Report: Road Safety Audit Stage 1

Report Title: New Highway Access, Barnham Road, Eastergate, West Sussex

Date: June 2021

RESPONSE REPORT

Project: The Croft Medical Centre		
Title: Proposed Access Arrangement and Visibility Splays		
Scale: 1:250 (@ A3)		
Notes:		Revision: A
Drawing: 2011094-01

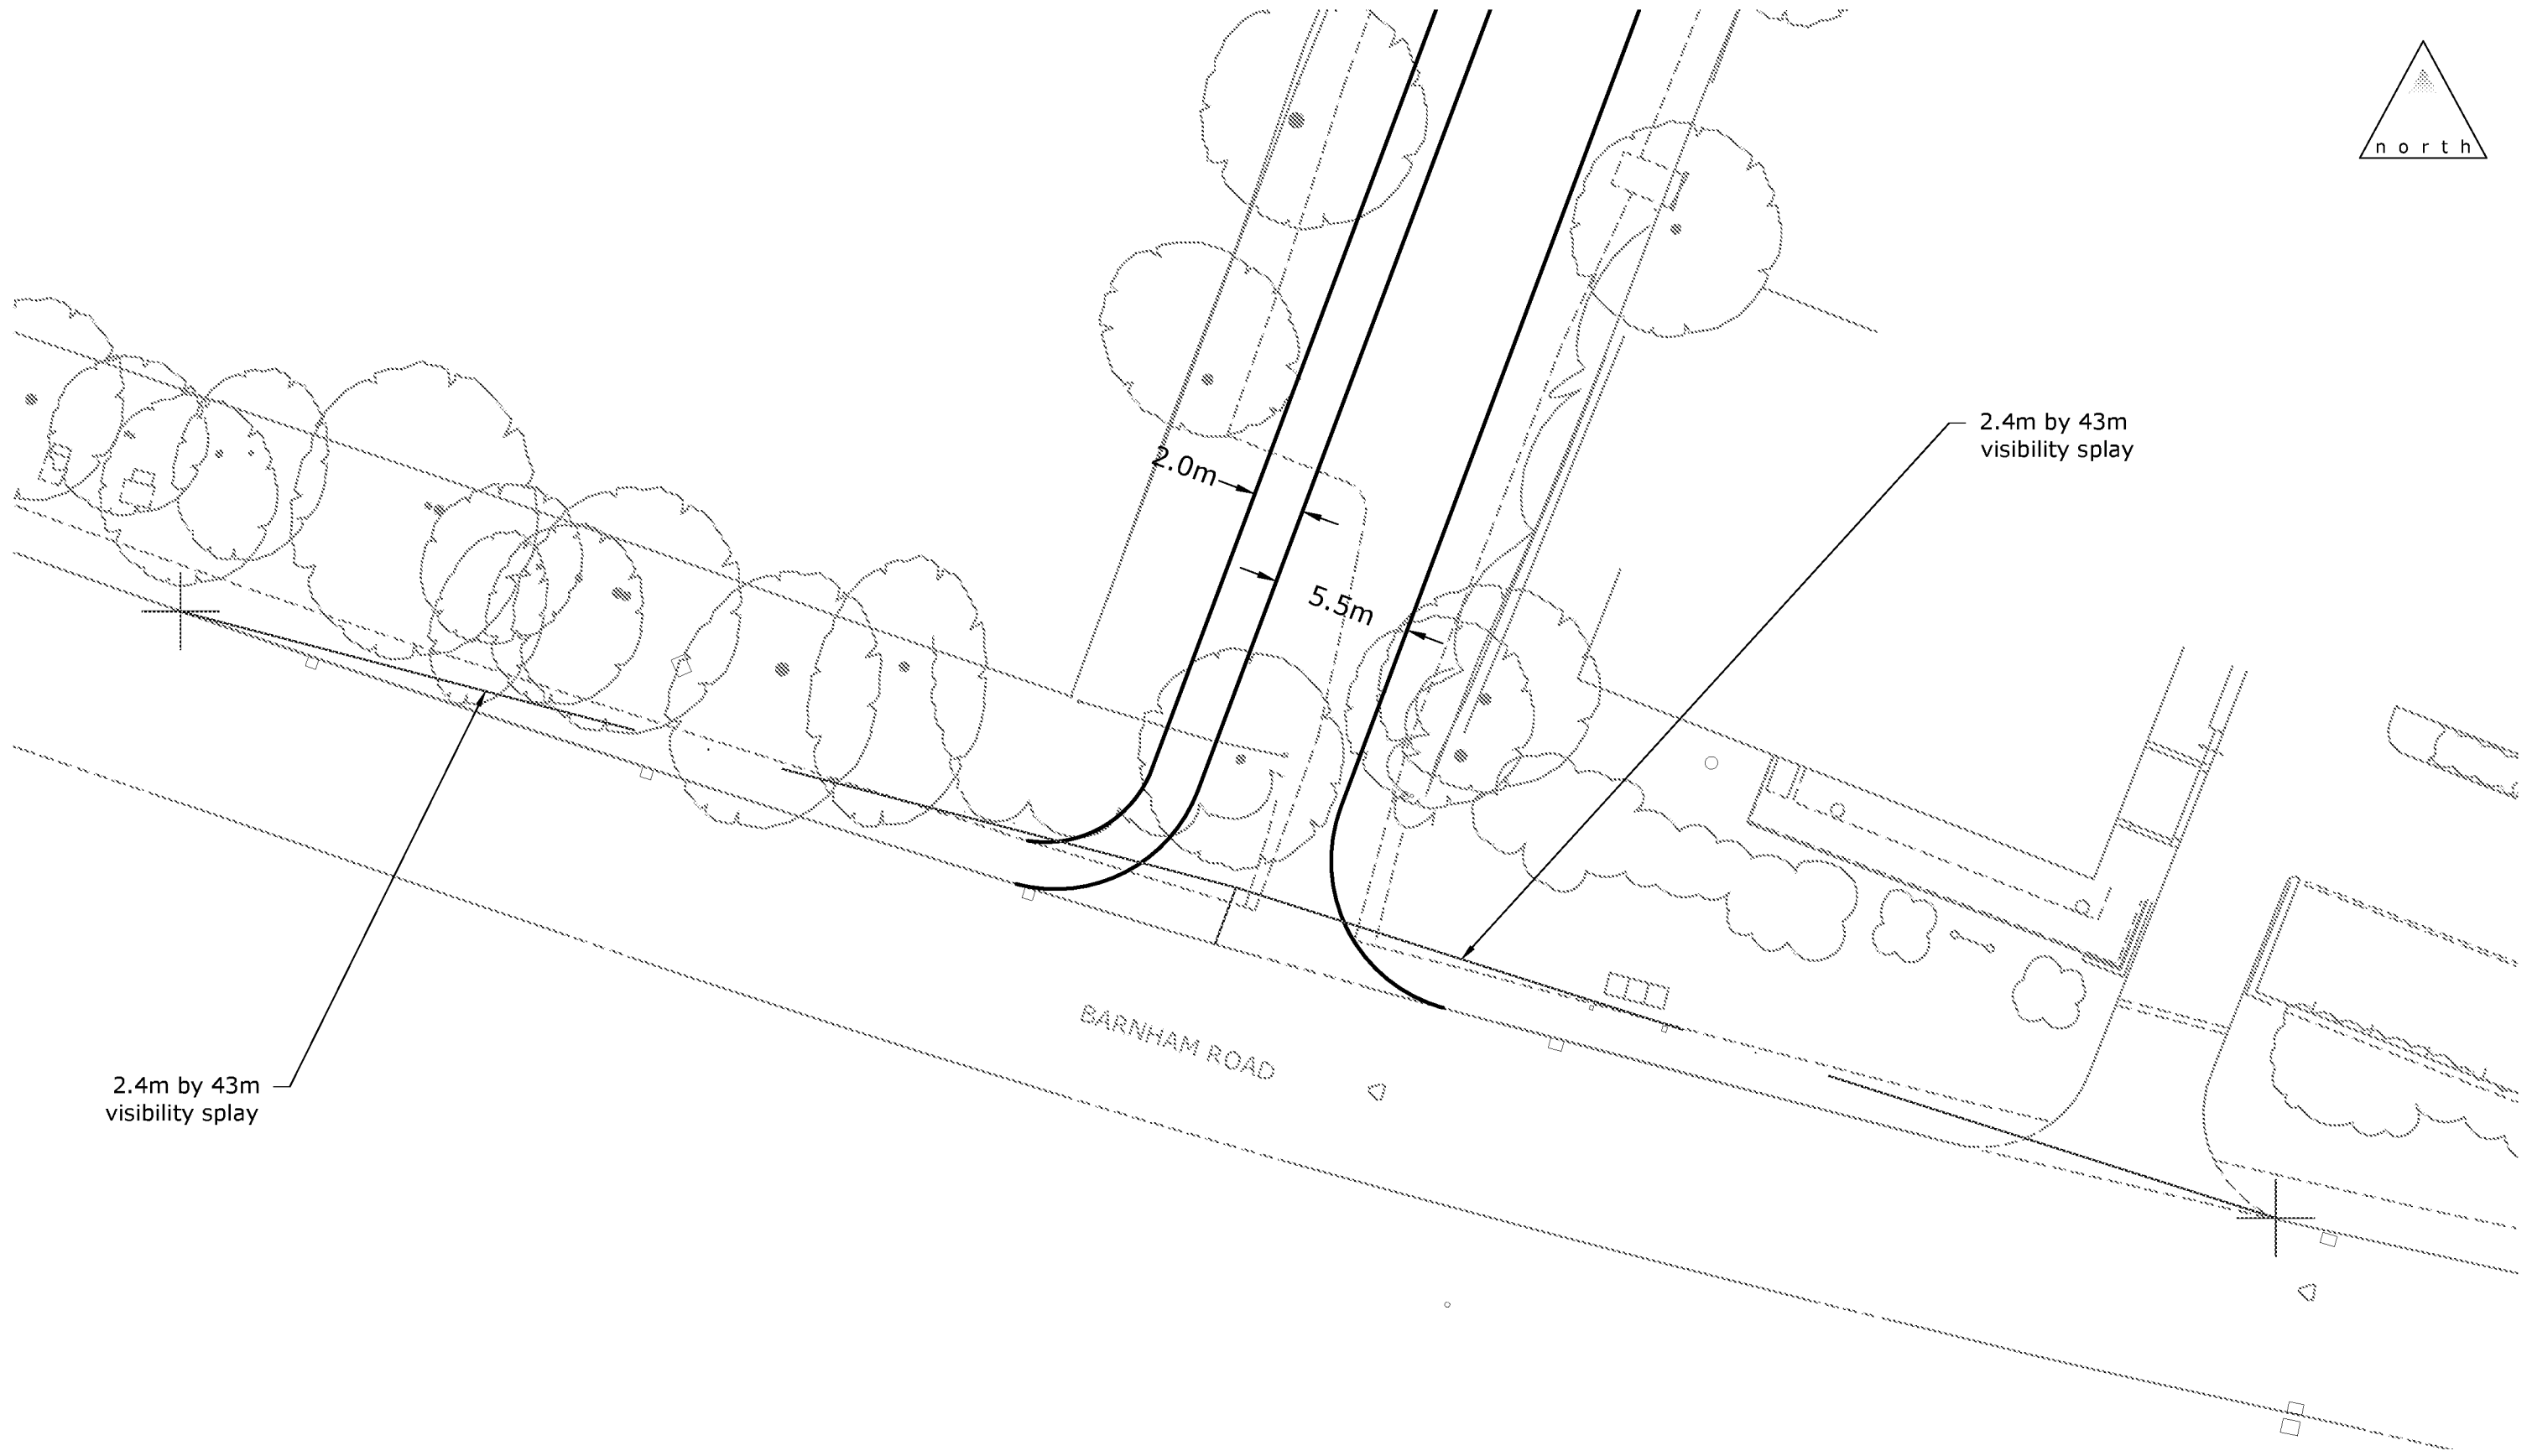
RSA Problem	RSA Recommendation	Design Organisation Response	Overseeing Organisation Response	Agreed RSA Action
2.3.1 It was observed that the existing unmade access road slopes down to Barnham Road. A future side road slope could result in vehicles rolling forward into the path of southbound vehicles on Barnham Road and collision occurring	It is recommended that the detailed design includes a flattish section of access road to the give way line to reduce the risk of roll forward incidents	This comment is noted. The detailed design of the revised access junction will include a flatter section to avoid the issue raised.	The Overseeing Organisation is satisfied that this issue can be resolved at Detailed Design as the access works are going to be implemented via a S278 agreement.	To be resolved at Detailed Design.

2.4.1 It was observed that there is a northbound bus-stop located a short distance to the south of the proposed access, but no existing crossing point for visitors to the Medical Centre to cross Barnham Road. There is a risk of pedestrians crossing from unsafe locations, or where there is a full height kerb upstand risking trip or fall	It is recommended that the Designer reviews the need for a formal dropped kerb crossing point between the access and the bus stop to assist pedestrian movement/desire lines.	The revised access junction arrangement shown on Drawing SK01 Revision C illustrates a dropped kerb crossing point located between the access and the bus stop. This could be dealt with via any Section 278 agreement for the access works.	The Overseeing Organisation is satisfied that this issue can be resolved at Detailed Design as the pedestrian crossing works are going to be implemented via a S278 agreement.	To be resolved at Detailed Design.

2.4.2 The northbound bus stop could be used by visitors to the Surgery. At present there is no hardstanding at the bus stop which is located within a verge area. Concern arises that a passenger could slip on wet grass while getting on or off the bus, risking personal injury	A hard standing area should be provided across the verge at the bus stop to assist bus passengers to get on and off the bus	Drawing SK01 Revision C illustrates an indicative area of hardstanding on the exiting verge to aid passengers departing the bus. This could also be implemented via the Section 278 agreement.	The Overseeing Organisation is satisfied that this issue can be resolved at Detailed Design as the bus stop improvement works are going to be implemented via a S278 agreement.	To be resolved at Detailed Design.
